A12 Chelmsford to A120 widening scheme

8.14 Statement of Common Ground with Braintree District Council

Statement of Common Ground with Braintree District Council

Regulation Reference	Reg 8(1)(e)
Planning Inspectorate Scheme Reference	TR010060
Application Document Reference	TR010060/EXAM/8.14
Author	A12 Project Team and National Highways

**FIGURE 13.1**

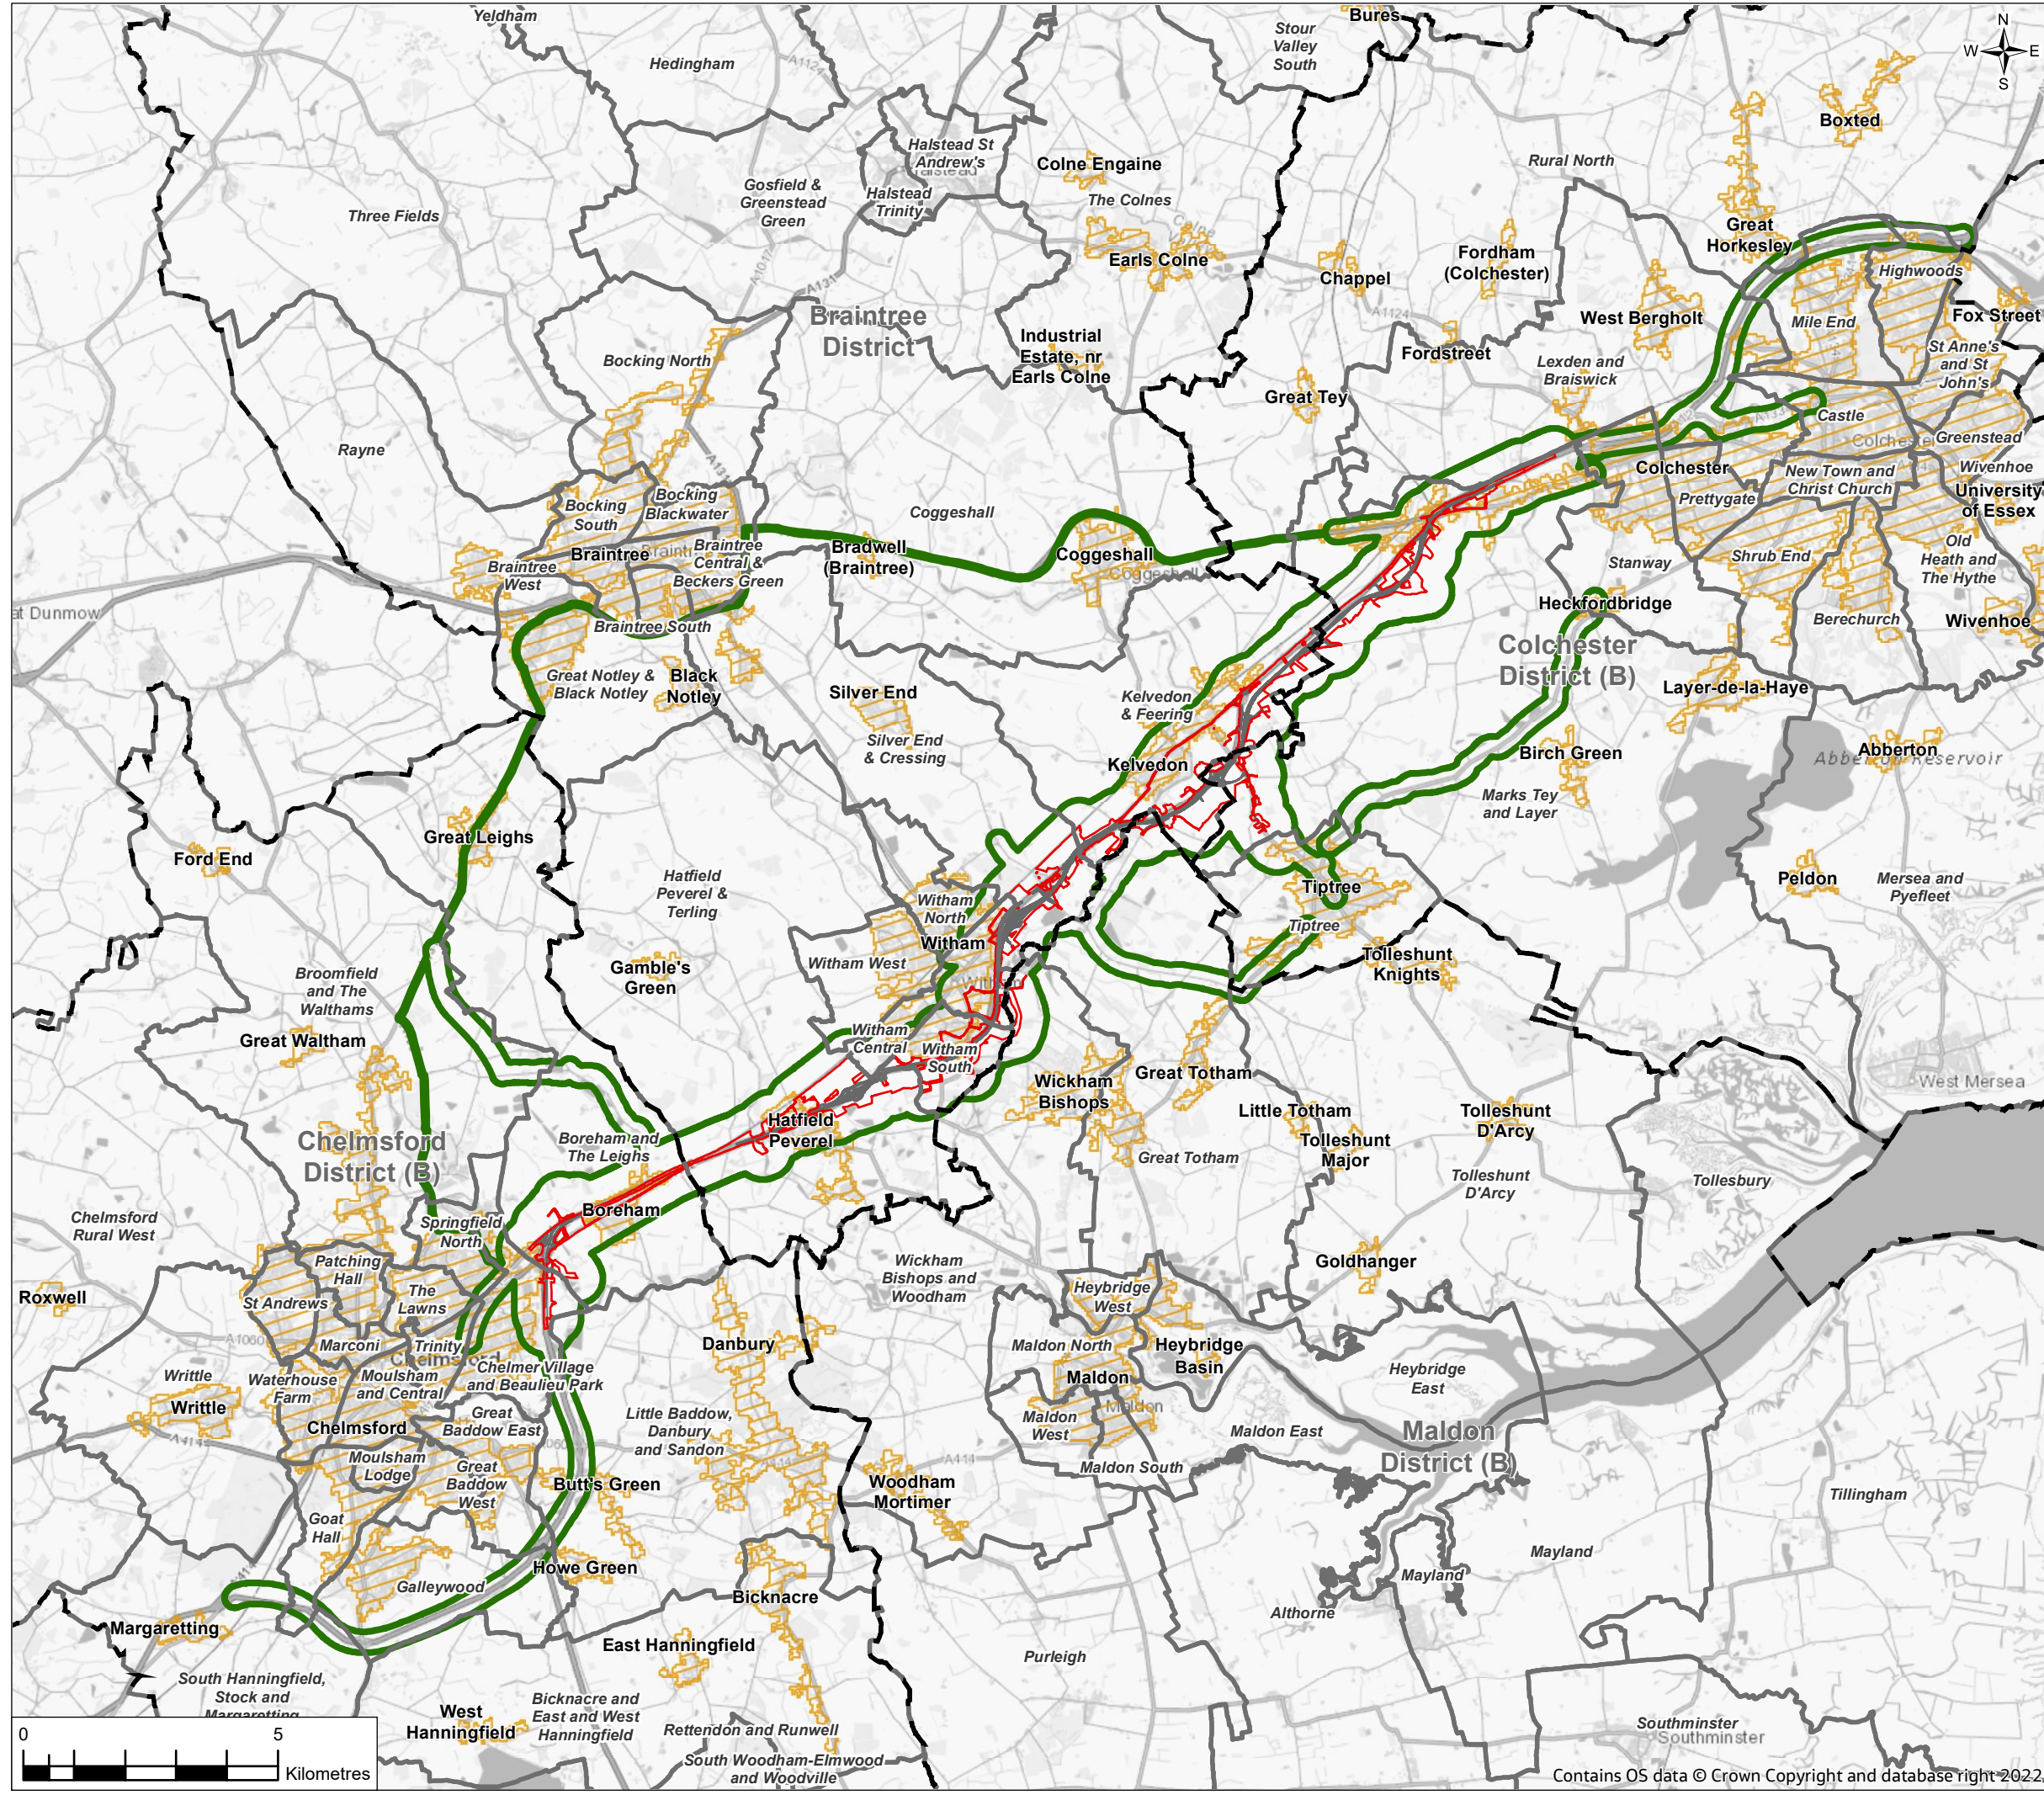
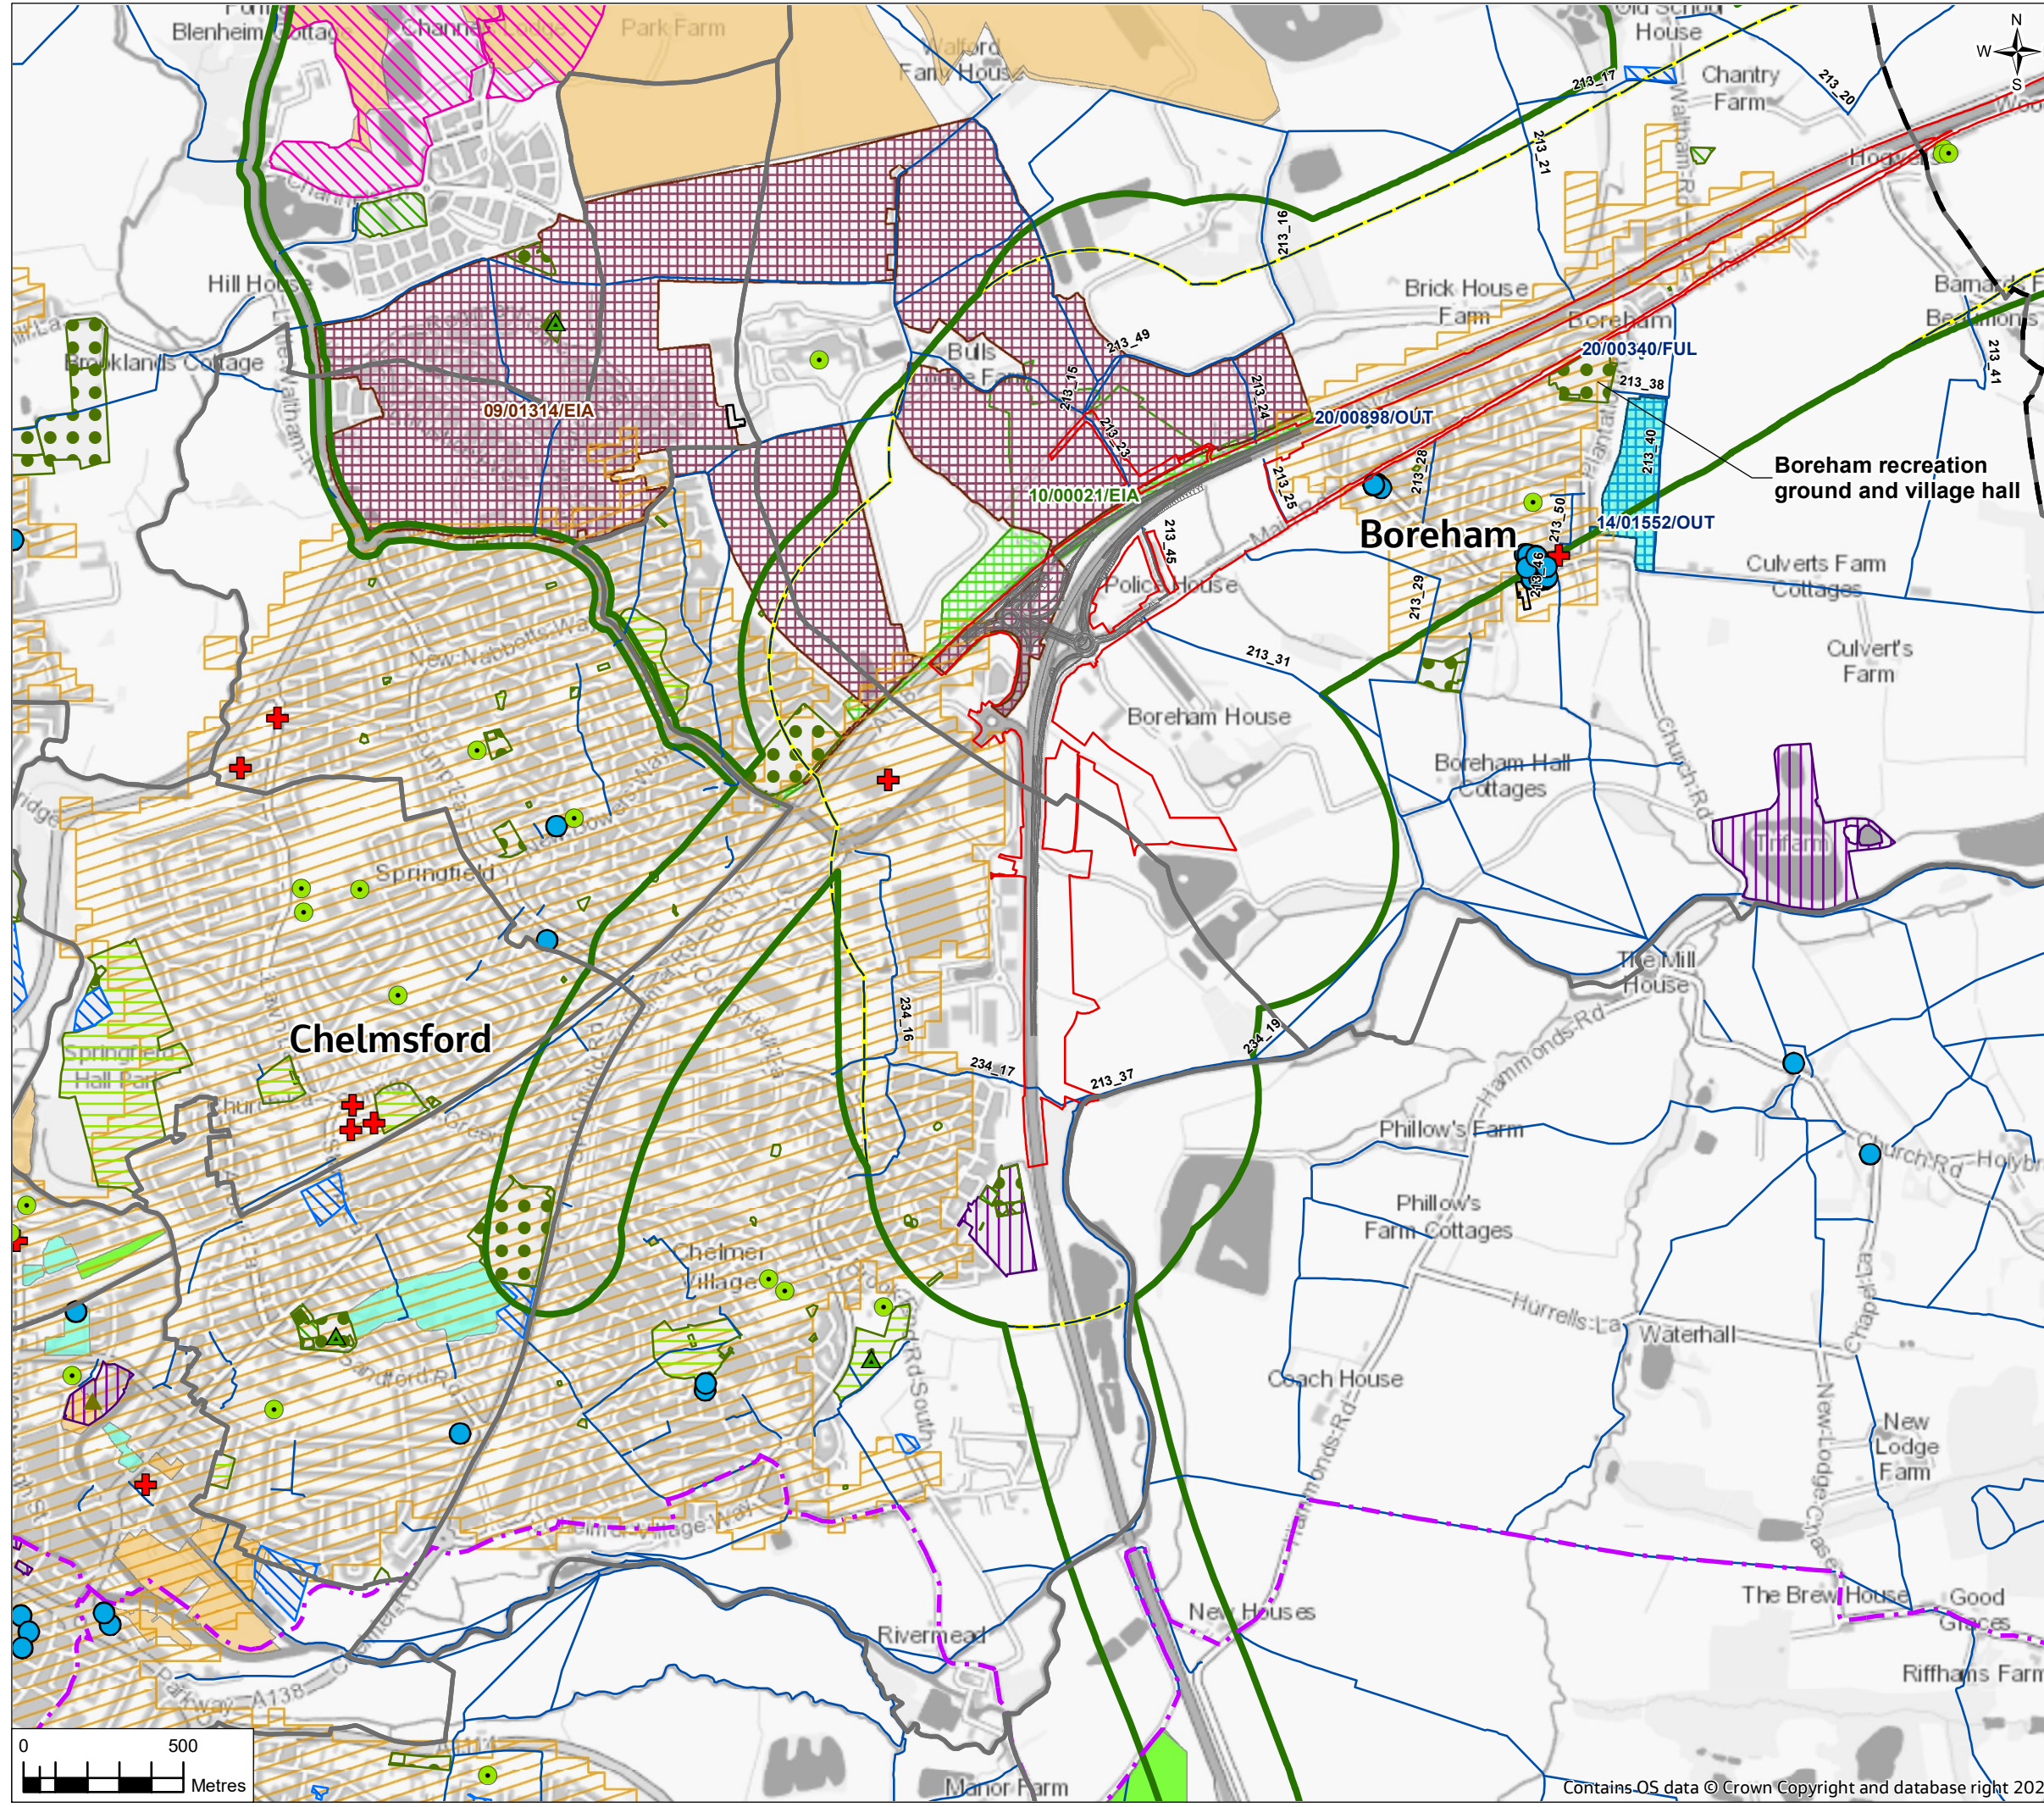
1.2	Environment – Human Health	Environmental Statement: Chapter 13: Population and human health [APP-080]	The human health study area in the assessment as shown on figure 13.1 should include Nounsley, although the addition of this village is unlikely to affect overall outcomes.	<p>The village of Nounsley is outside of the study area for air quality and noise, as well as outside of the land use and accessibility study area as defined by DMRB LA 112. It is not considered there would be any likely significant effects for this village that warranted a need to extend the study areas.</p> <p>However, the village has been considered in the wider context of likely origins and destinations for people who may interact with the land use and accessibility study area.</p>	Agreed. BDC agree that the Environmental Statement takes into account.	01/09/2022
